From: Martyn White <Martyn.White@arun.gov.uk>
Sent: 12 June 2021 08:52
To: Planning.Responses <Planning.Responses@arun.gov.uk>
Subject: WA/32/21/PL

WA/32/21/PL

Land at West Walberton Lane Walberton BN18 0QF

Construction of 30 No. dwellings together with associated access, parking, public open space & landscaping. This site may affect the setting of listed buildings, affects the character & appearance of the Walberton Green Conservation Area, is a Departure from the Development Plan & is in CIL Zone 3 & is CIL Liable as new dwellings.

House Type 3BH3

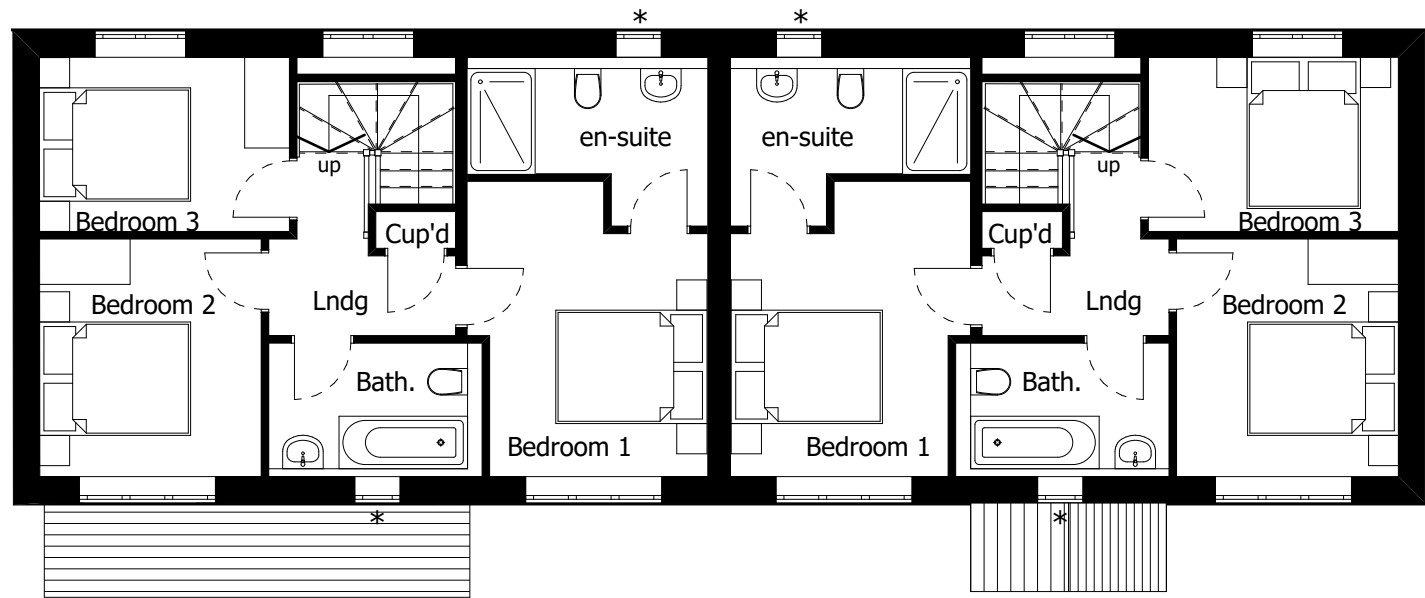
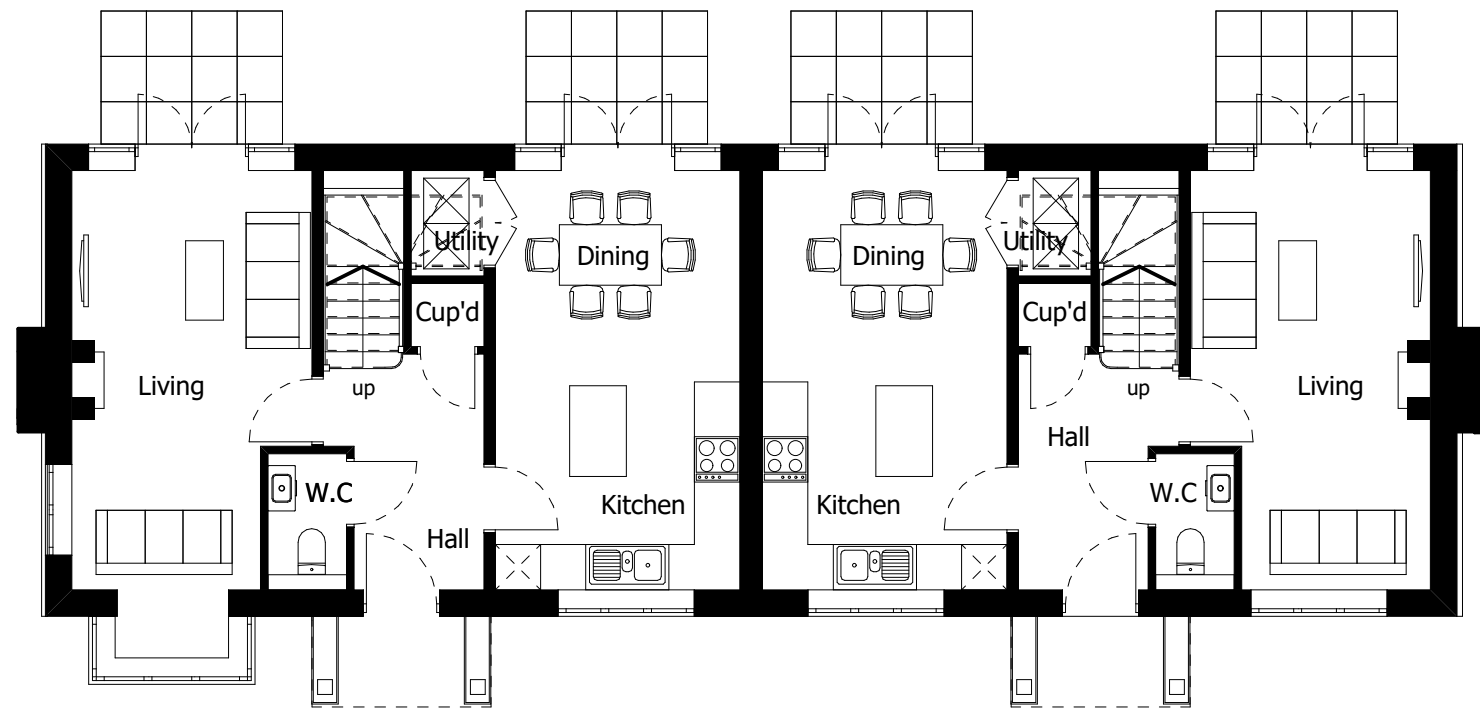
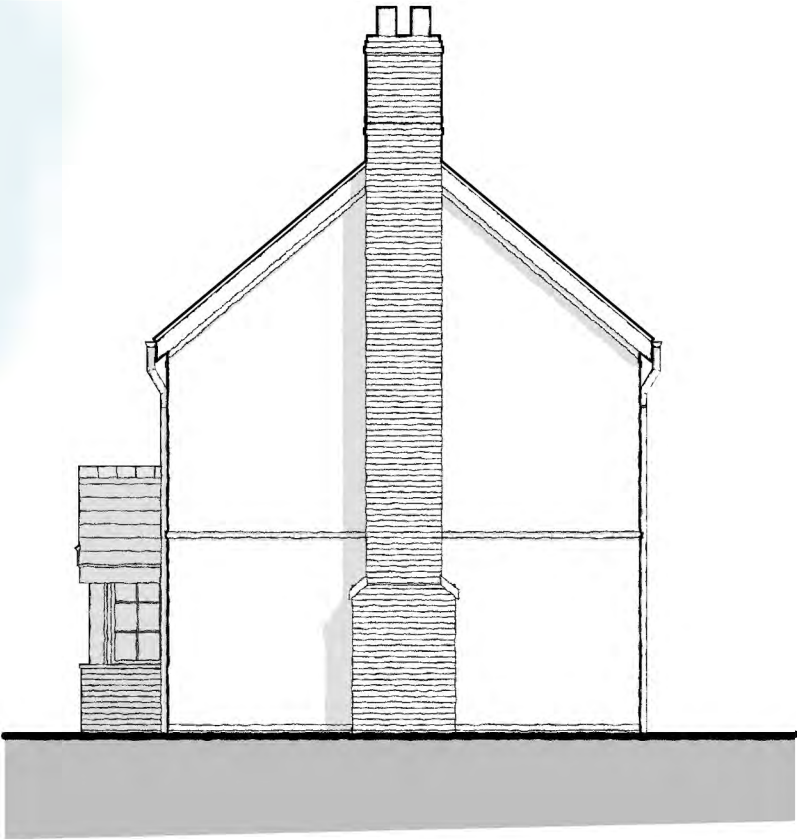
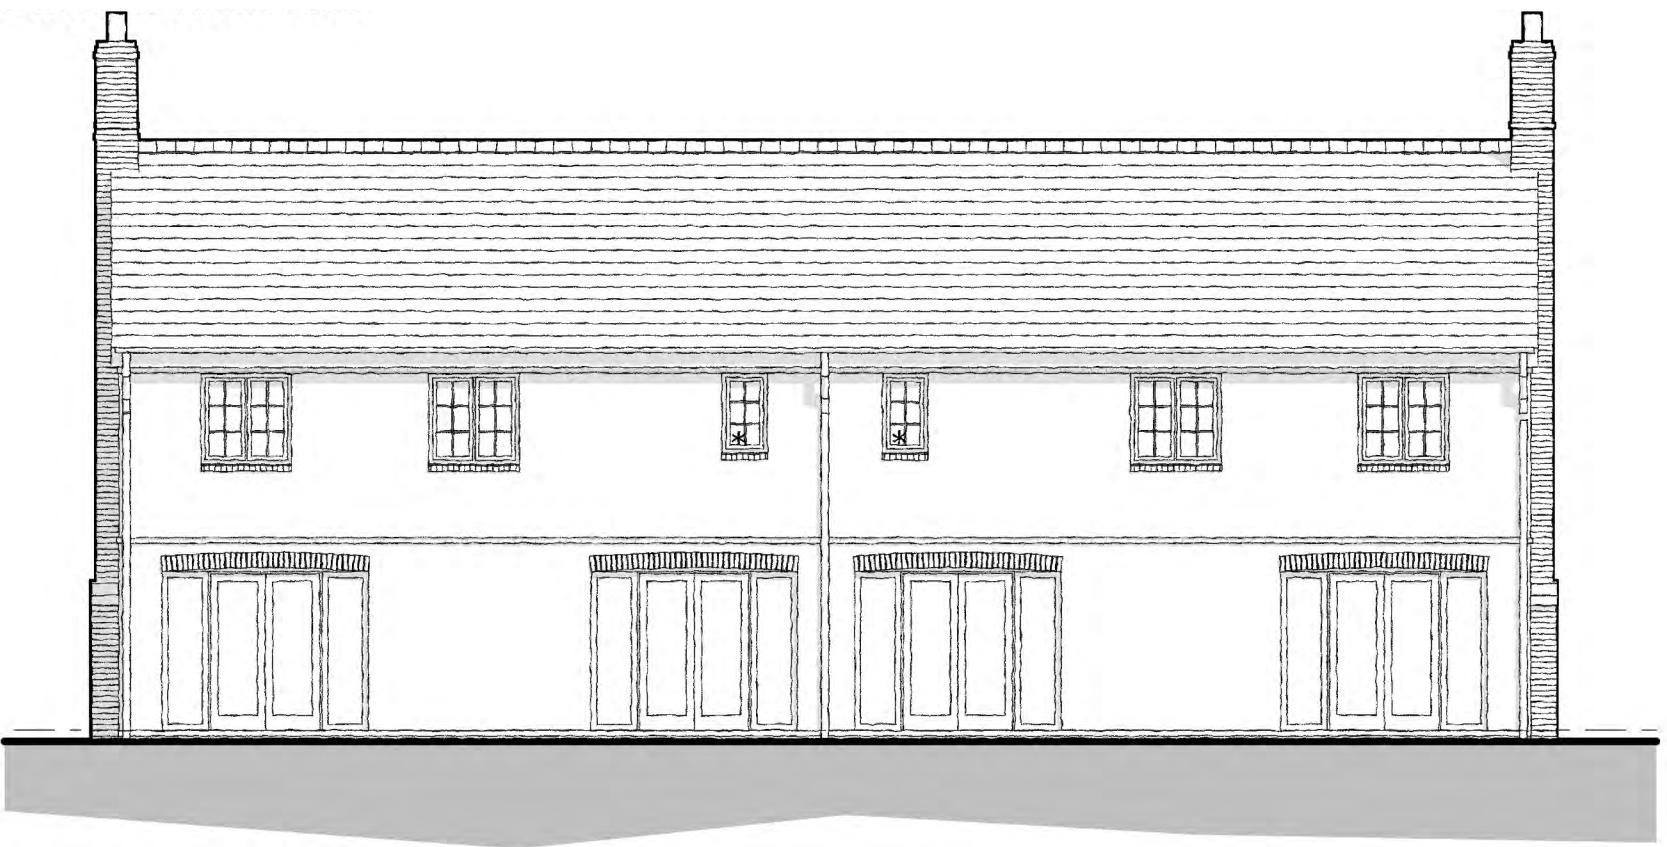
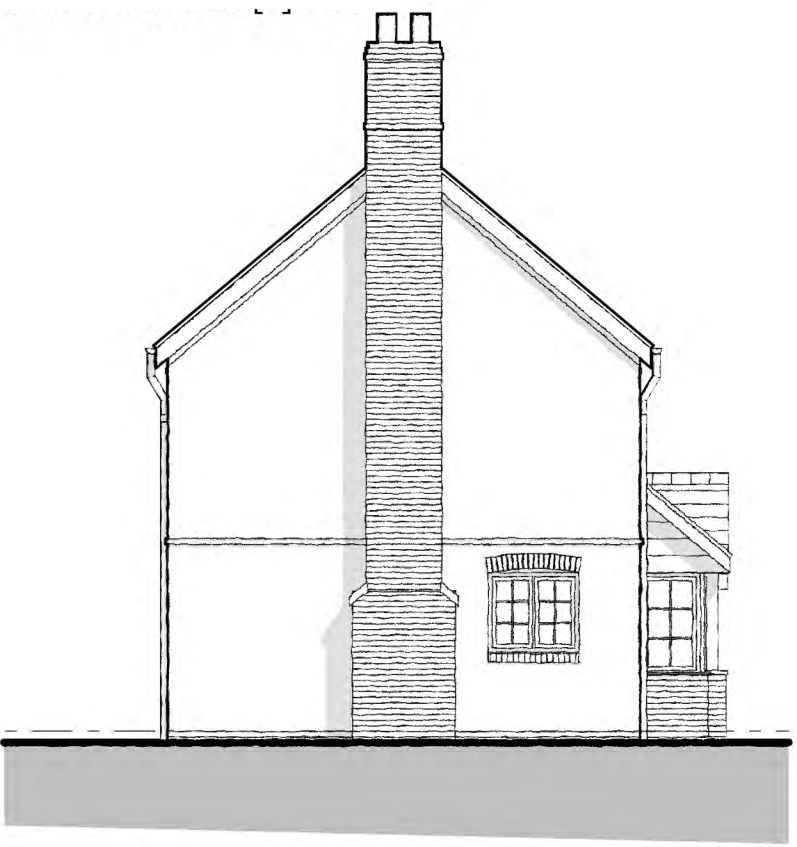
Any development in a location such as this will require all of the materials, joinery details and finishes to be of a very high standard. These should be appropriate for a conservation area and include the use of traditional materials. This is as opposed to the use of UPVC for windows and rainwater goods and what appears to be coloured concrete roof tiling etc as indicated on the plans. The designs of the properties should be based on a thorough assessment of the traditional buildings within the conservation area and locality, as opposed to more recent ones, in order to ensure that they more closely reflect and support the established local character.
